From: Bernie Harverson
Sent: 26 September 2017 12:35
To: Michael Eastham
Cc: Richard Martin; Joe Russell-Wells; Sue Howell
Subject: RE: A/99/17/OUT - Land South of Water Lane, Angmering

1. All demolition & construction works are to be carried out in strict accordance with:- **Arboricultural Method Statement Report Ref: and Tree Protection Plan ref:** Reference the PIC report & TP Plan here.

Tree Protection Plan

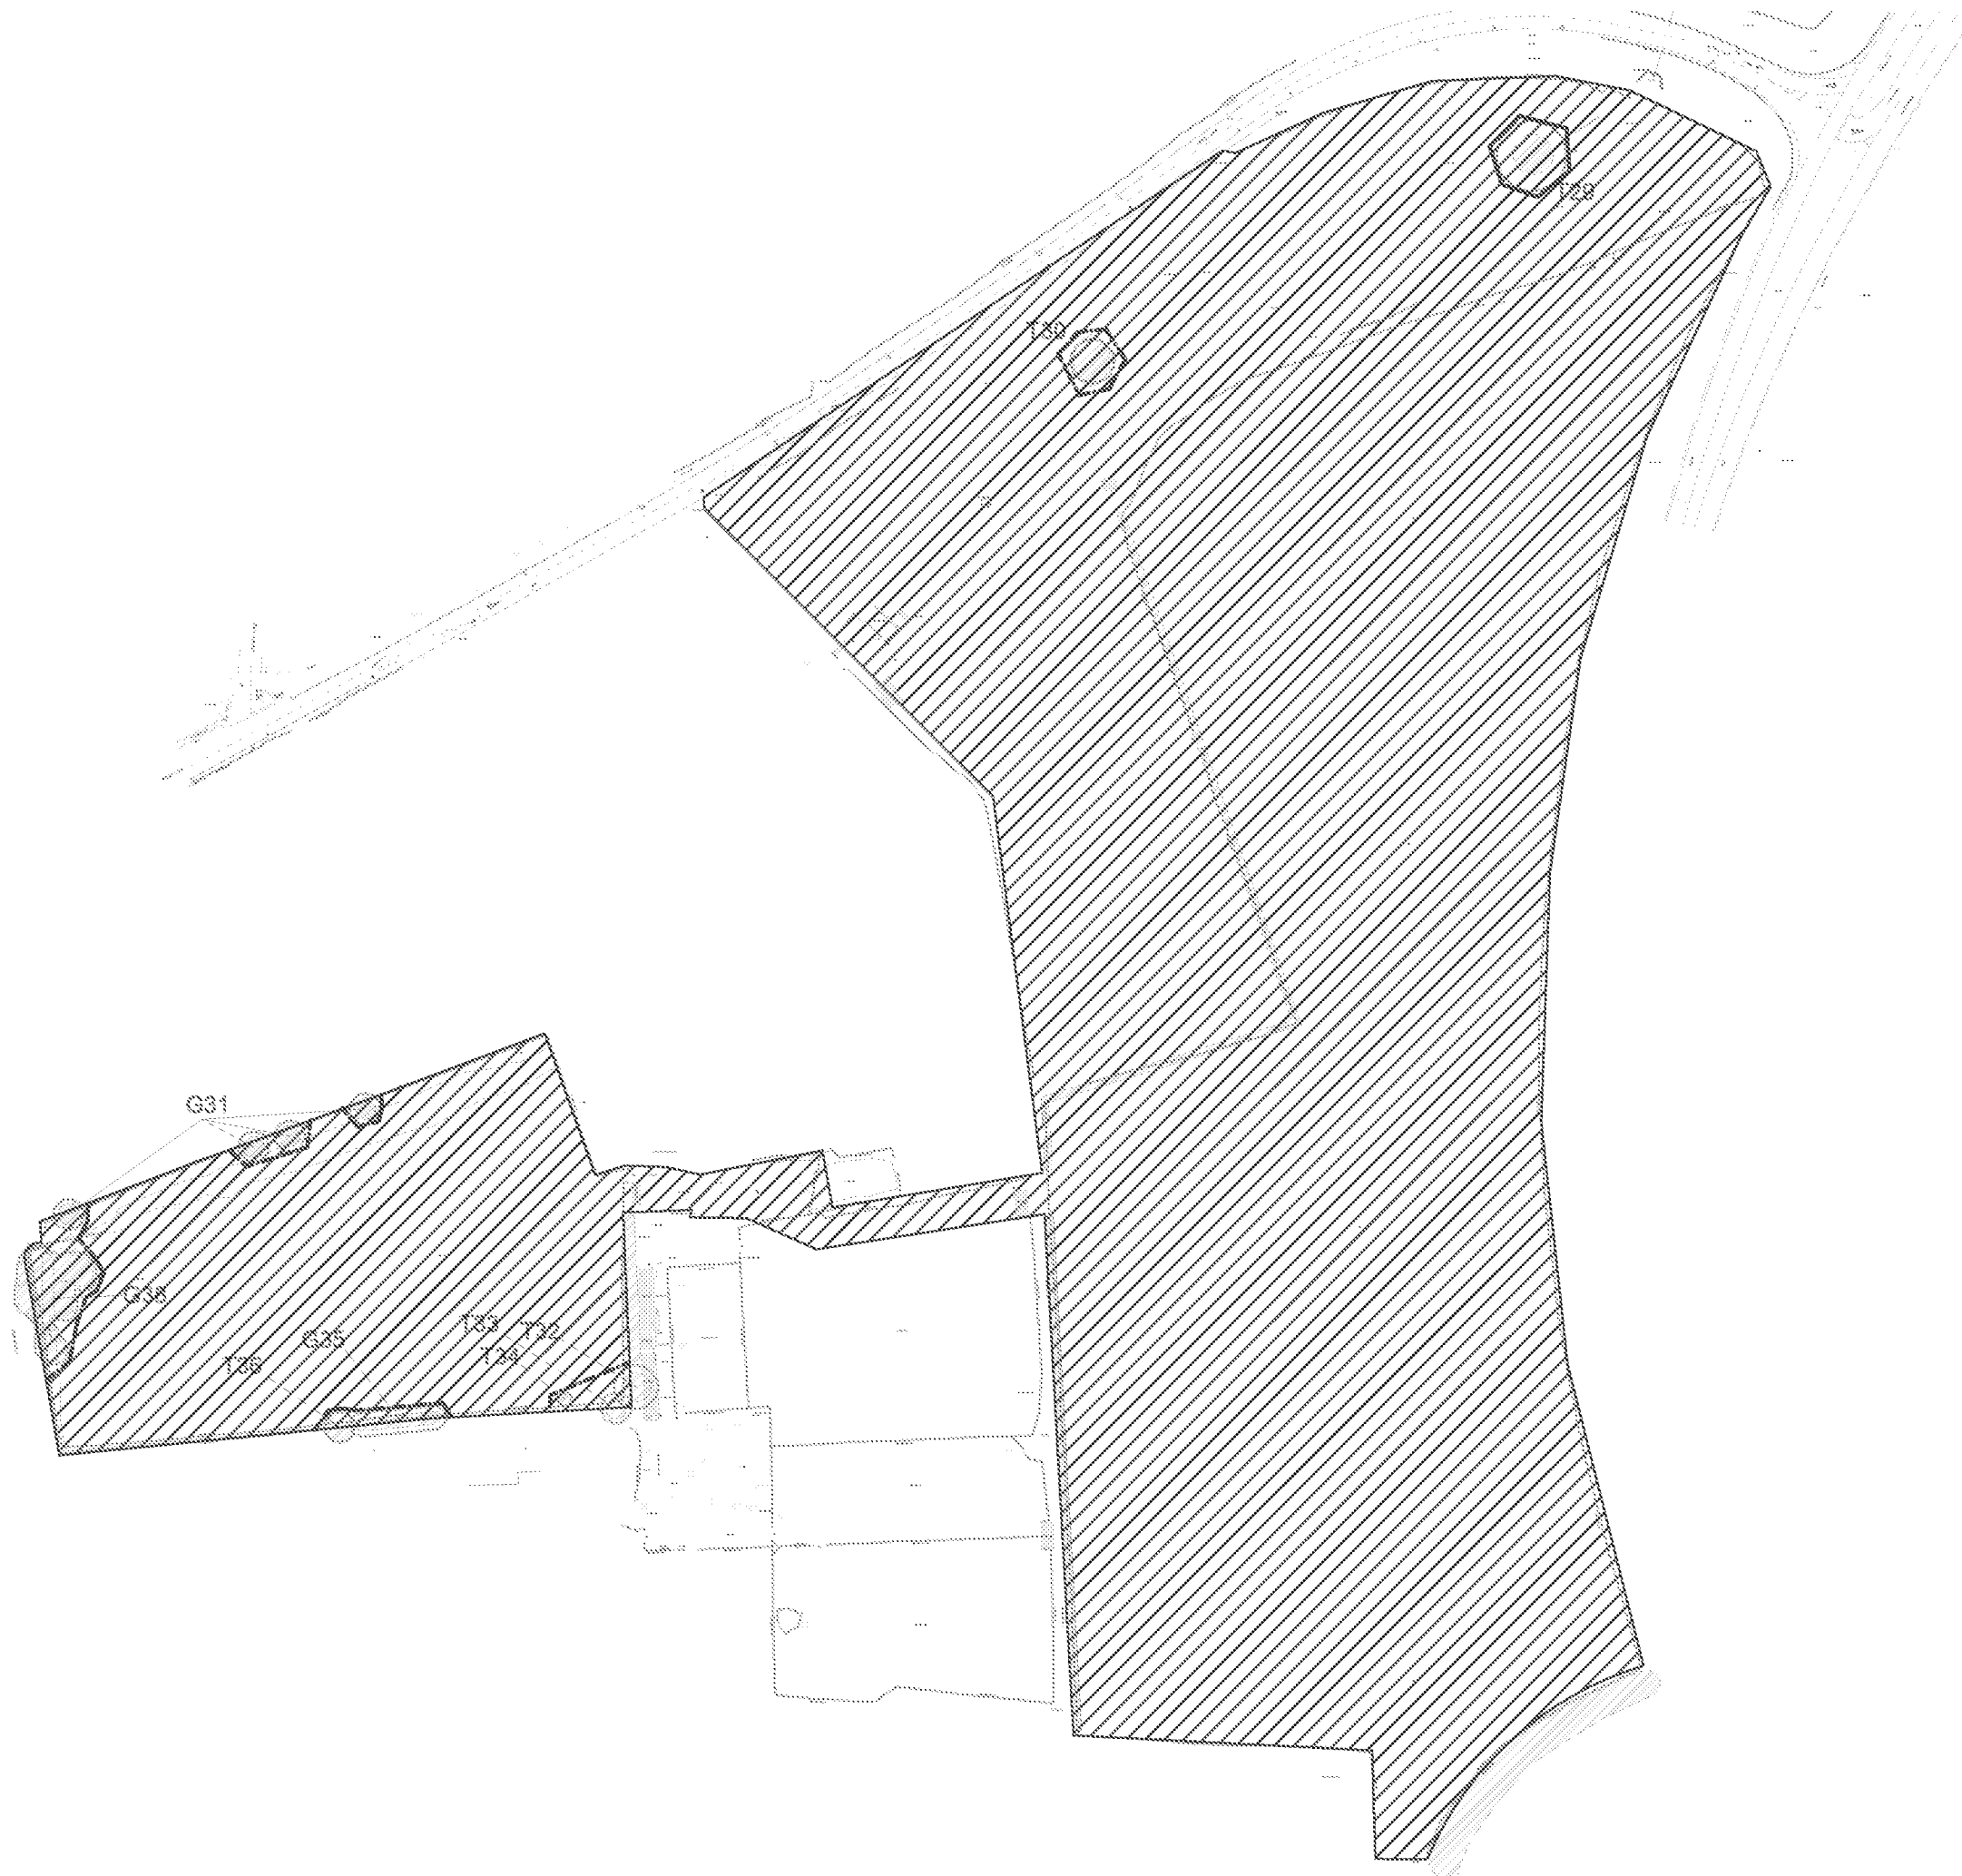
I also note that PJ Consulting refer to it as a Tree Protection Plan BUT it is drawn on a site location plan and without overlaying it on a set planning layout drawing it is strictly a Tree Constraints Plan and no more!!!.
